Rezoning Transportation Analysis
Petition Number: Insert Zoning Petition #2021-015
General Location Identifier: 11504601, 11504613

Reviewer: [Kevin Parker]
[Kevin.Parker@charlottenc.gov]
[704-432-6511]

Revision Log:	Date	Description
	02-25-2021	First Review (KP)
	03-25-2021	Second Review (KP)
	04-15-2021	Third Review (KP)

**HOLABIRD LANE & WEST BOULEVARD  
CHARLOTTE, NC  
REZONING PLAN**

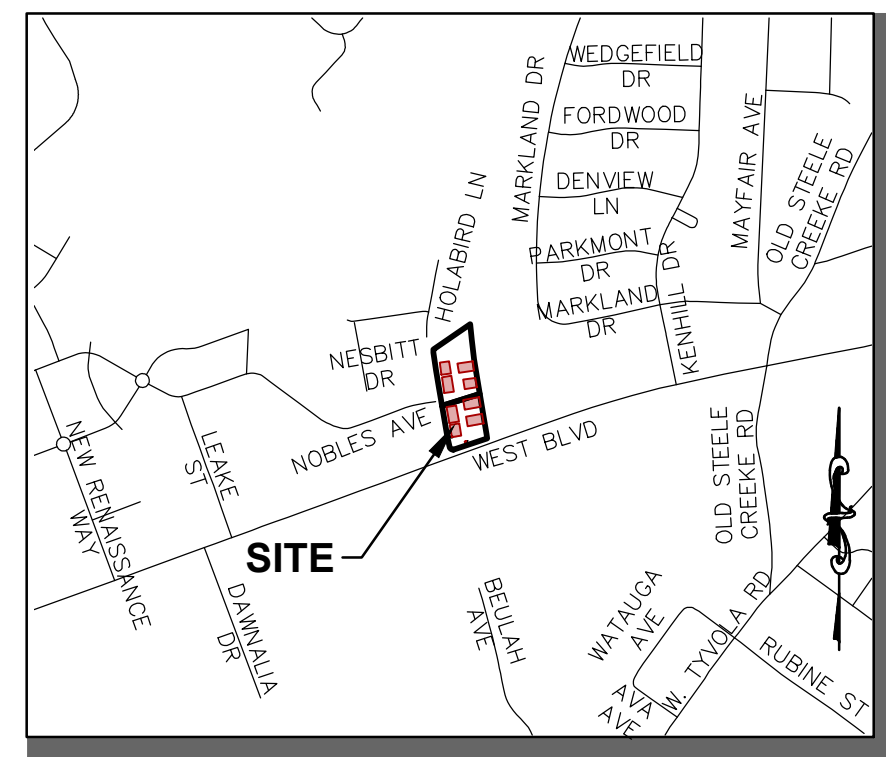
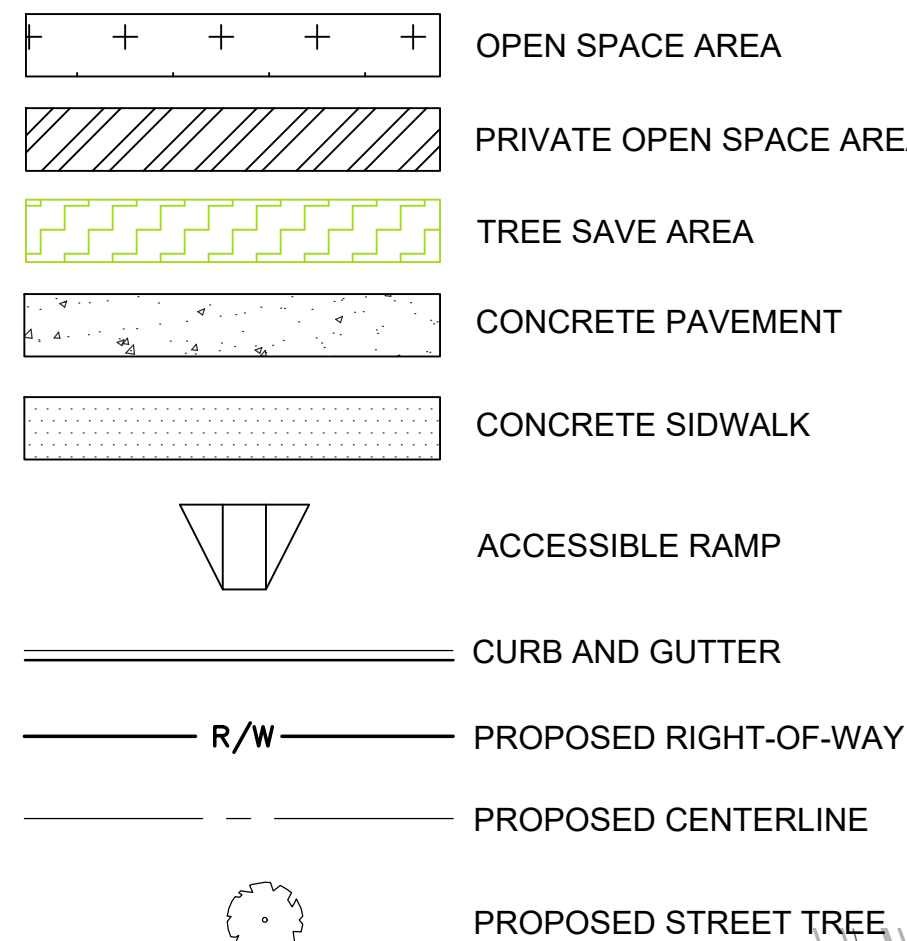
- a. ~~West Boulevard:~~ The future curb line for West Boulevard will be 32.5 feet from the existing road centerline to back-of-curb.
- b. ~~Holabird Lane:~~ The petitioner will construct the curb 17.5 feet from the existing road centerline to the back-of-curb. **Update to Comment as a result of 03/16/2021 Site Plan: Label and dimension the curb line from the centerline of Holabird.**

Revise the site plan by labeling and dimensioning the back-of-curb from the centerline of each road.

Label and dimension the right-of-way from the centerline of each road.

Label and dimension each item from the centerline of each road.

Label and dimension from the centerline of West Boulevard.

- 6. ~~Revise the site plan and conditional notes to commit to construct on-street parking along the site's Holabird Lane frontage. This on-street parking will be constructed in accordance with CLDSM Details 50.09C and 50.09D.~~
- 7. **Unaddressed Comment:** Revise the site plan and conditional notes by committing to extending the 8-foot planting strip and 6-foot sidewalk, along Holabird Lane, to the existing sidewalk at the cul-de-sac of Holabird Lane. This sidewalk will provide a pedestrian connection from West Boulevard to the Southwest Recreation Center where a gap currently exists and would assist CDOT in finishing an important pedestrian connection.

11. **New Comment From 03/16/2021 Site Plan:** Revise the site plan to include 4 curb ramps at the private access drive and Holabird Lane/Nobles Avenue Intersection, in accordance with PROWAG.
